Campbell's Cove

Deletion of Stage 4 Ports Authority Works

SYDNEY HARBOUR PROMENADE DESIGN RESPONSE TO SUBMISSIONS

NOVEMBER 2017

08 BRONZE PLATE SHORELINE MARKERS
SCALE 1:2.5

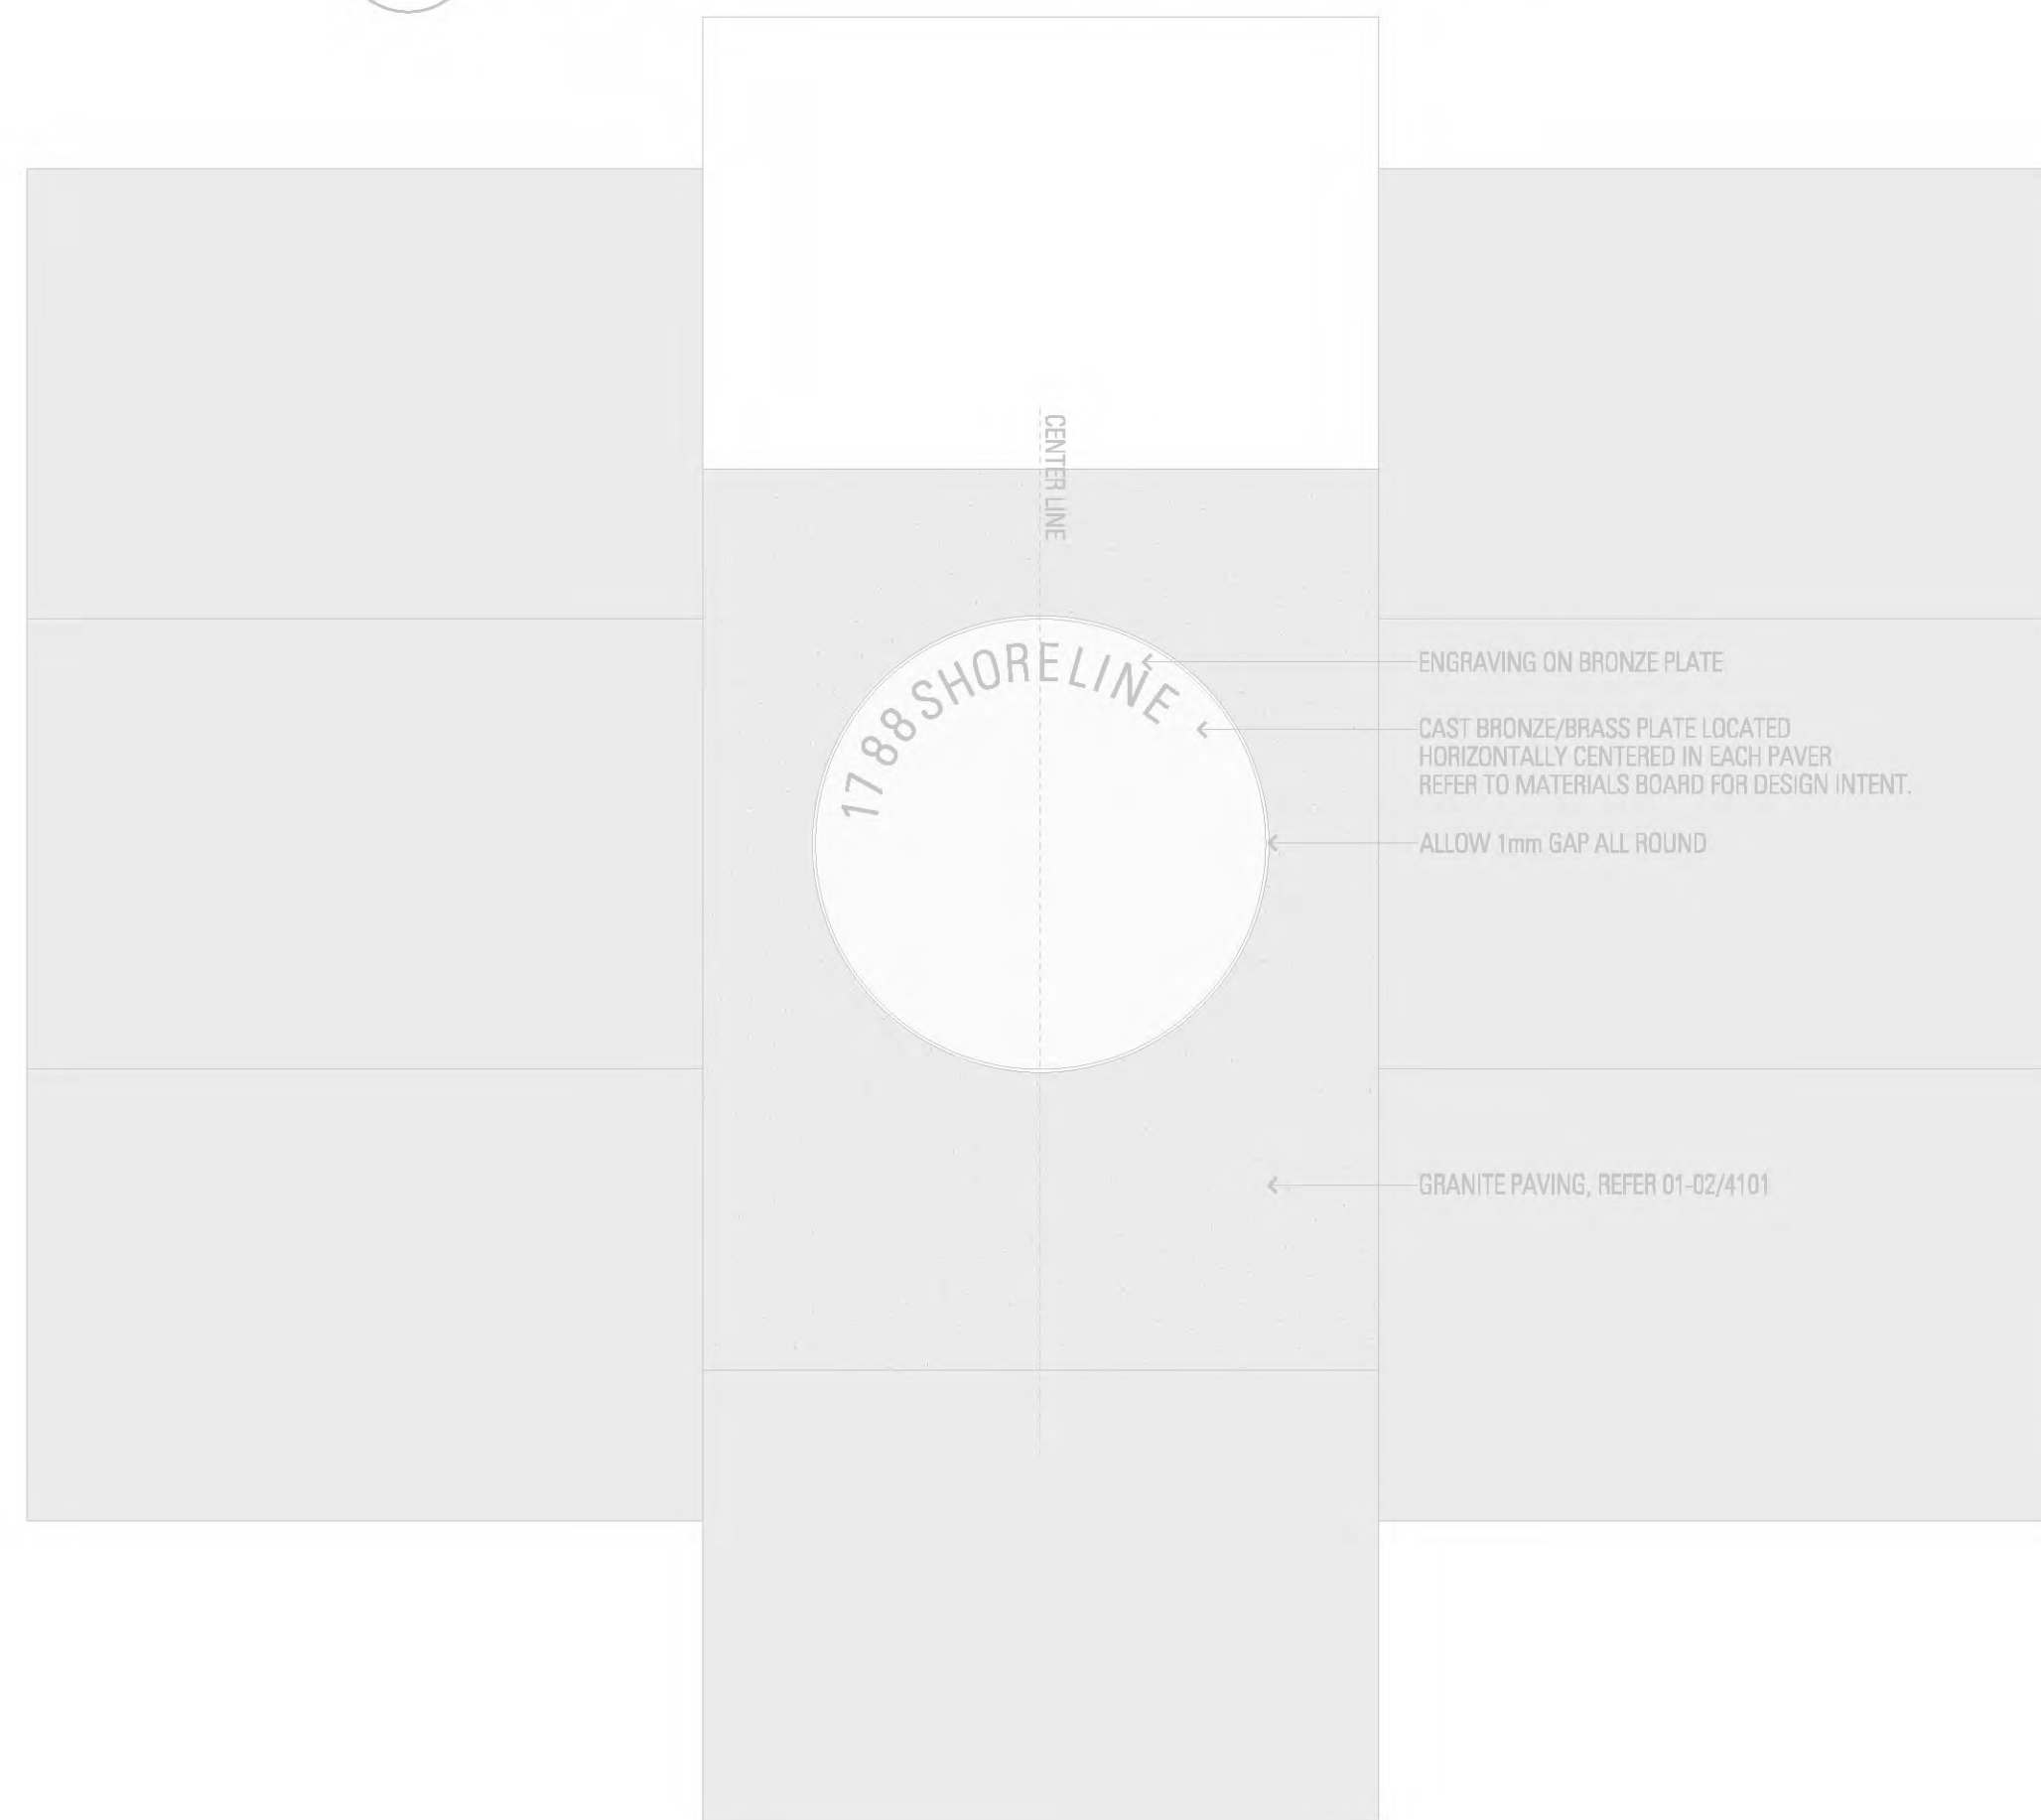
"It is recommended that the interpretive shoreline paving detail should be deleted and replaced with bronze inlays, as currently exists in Circular Quay East."

We support the retention of the interpretive shoreline as a continuation of the Campbell's Stores lease area, including the identifying bronze inlays.

Taking these comments into consideration, Context's design response provides a simplified paving pattern in line with the Circular Quay Public Domain Manual, in a dark colour with 30% light coloured inflections in 'Austral Verde' and 'Juparana'. The pavement design utilizes the austral black granite paver arranged in the standard City of Sydney arrangement as the body paver unit. A variety of finish types in conjunction with the 30% contrast will give a level of diversity and complexity to the pavement design and help to unify the overall pavement treatment of the site.
